Planning Consultation Request

Application No.	2025/90708
Proposed Development:	Discharge of details reserved by conditions 3 (Construction (Environmental) Management Plan), 6 (Temporary surface water management details), 8 (Proposed internal adoptable roads), 9 (Permanent site entrance details), 16 (Surface water attenuation details), 17 (Details of Swale/ditch management), 19 (Phase II Site Investigation details), 20 (Remediation Strategy), 25 (Noise Impact Assessment), 30 (Arboricultural Method Statement/ Tree Protection Plan), 34 (Biodiversity Gain Plan) of permission 2024/91260 for Variation of conditions 2 (plans and specifications) and 35 (removal of permitted development rights) on previous permission 2021/92801 for erection of 291 dwellings with associated works and access from Hunsworth Lane and Kilroyd Drive – revisions to house types, unit size mix and layout
Location:	Land at, Merchant Fields Farm, off Hunsworth Lane, Cleckheaton

Consultation Response from KC, Lead Local Flood Authority
2025/90708 Land at, Merchant Fields Farm, off Hunsworth Lane, Cleckheaton
Discharge of details reserved by conditions 3 (Construction (Environmental) Management Plan), 6 (Temporary sur

SECTION A-A

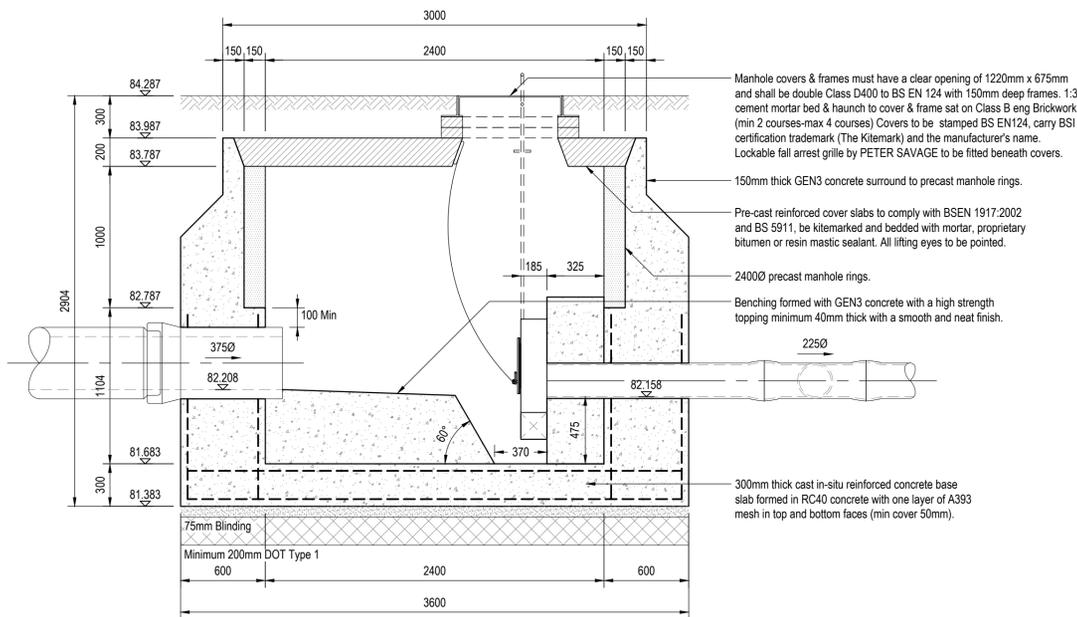
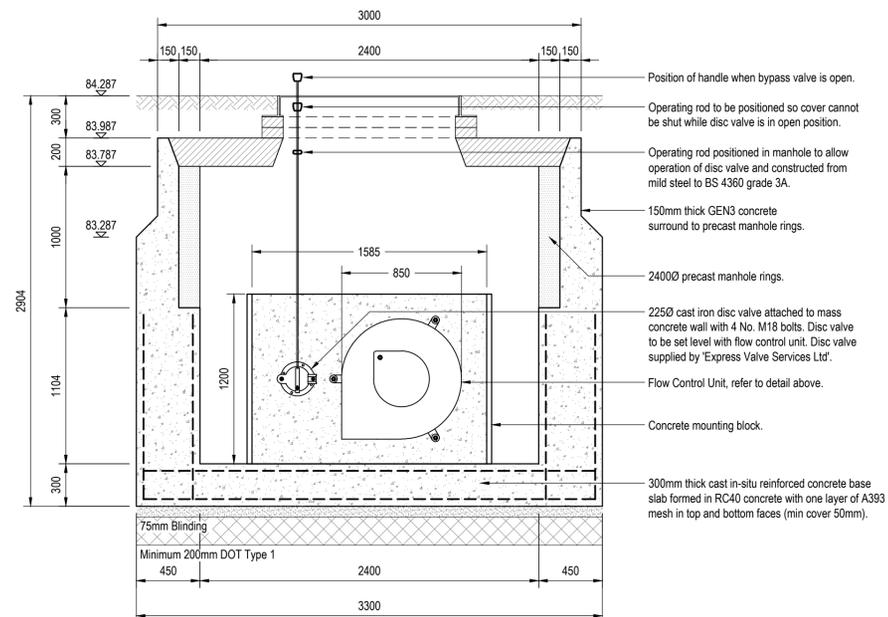
There is no objection to headwall details for inlet to the detention basin and outfall to watercourse. The outlet from the pond does require a trash screen in accordance with modern standards/current thinking. This means a horizontal section of bars before a 45 degree or 60 degree fall to within 150mm clearance of the invert of the outgoing pipe. This allows for an overspill even when the angled screen is blocked and free passage of small sized debris. The Principal Engineer should oversee the health and safety aspects of this design including maintenance as part of CDM Regs 2015. For further information on acceptable design please contact floodmanagement@kirklees.gov.uk.

There are no plans and cross section details of the tanks which may be crate storage. One tank has no access shown. It is unclear how this can be inspected or cleared of silt (method of silt prevention). No manufacturer has been selected and therefore there is no guarantee for lifespan of a product that can't readily be inspected. Without this and with no independent accreditation, such as a BBA certificate, Kirklees will impose a nominal 25 year replacement interval on such tanks that needs to be included in the maintenance and management regime. Such an agreement can cease upon adoption by Yorkshire Water or a NAV equivalent who will have their own maintenance regimes as a Statutory Undertakers.

Gradients of the sides of the attenuation basin need to be shown and proven as 1 in 3 at steepest. 1 in 4 or flatter is preferable as is a step up from the lowest level before a 1 in 3 gradient.

APPENDIX 1

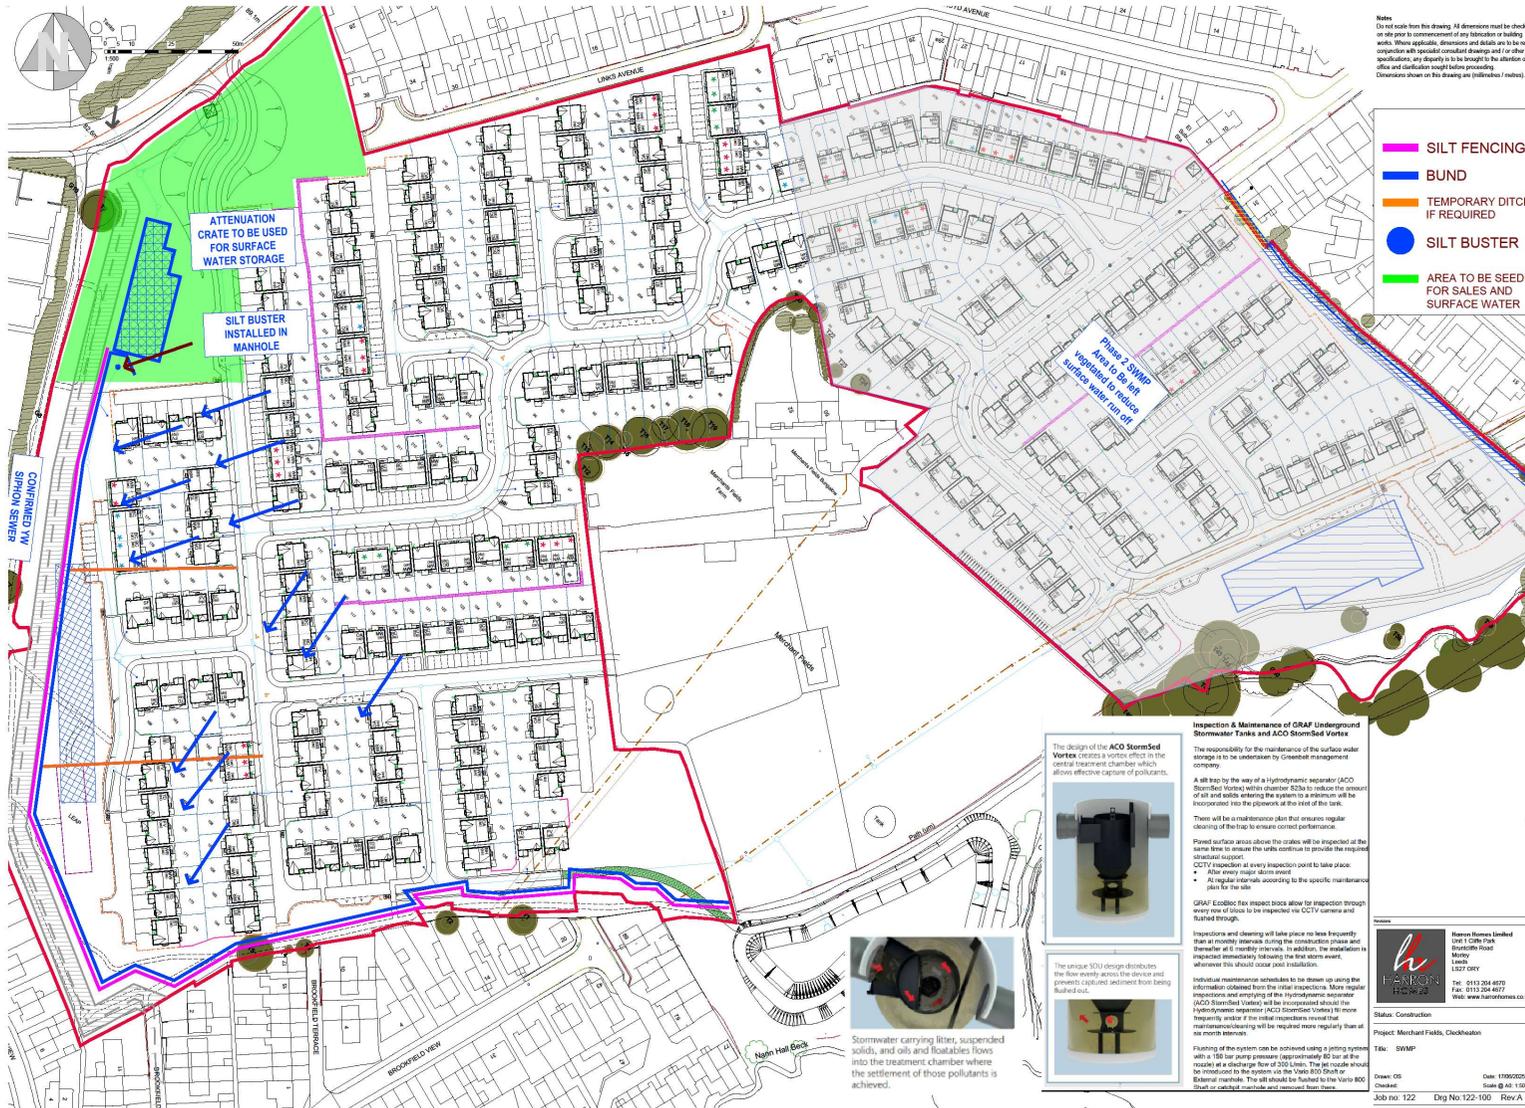
A narrative has been supplied but drawings still show one phase. At the very least pre and post attenuation installation phases are required. However, in this case some land is not to be soil stripped straight away so such phases should be detailed in description and plan.

Latter phases should include how drainage infrastructure is protected from sediment ingress from gullies and manholes for example.

We also believe water stored by bunds is likely to require sediment to settle out before discharging to watercourse. A tanker should be the last resort. Klargesters or similar are often used as a back up where dealing with sediment proves to be an issue.

It is not clear from levels of bunds and topography where the 1 in 2 6 hours storm will site on site. This capability needs to be shown and this space's place in the development programme considered.
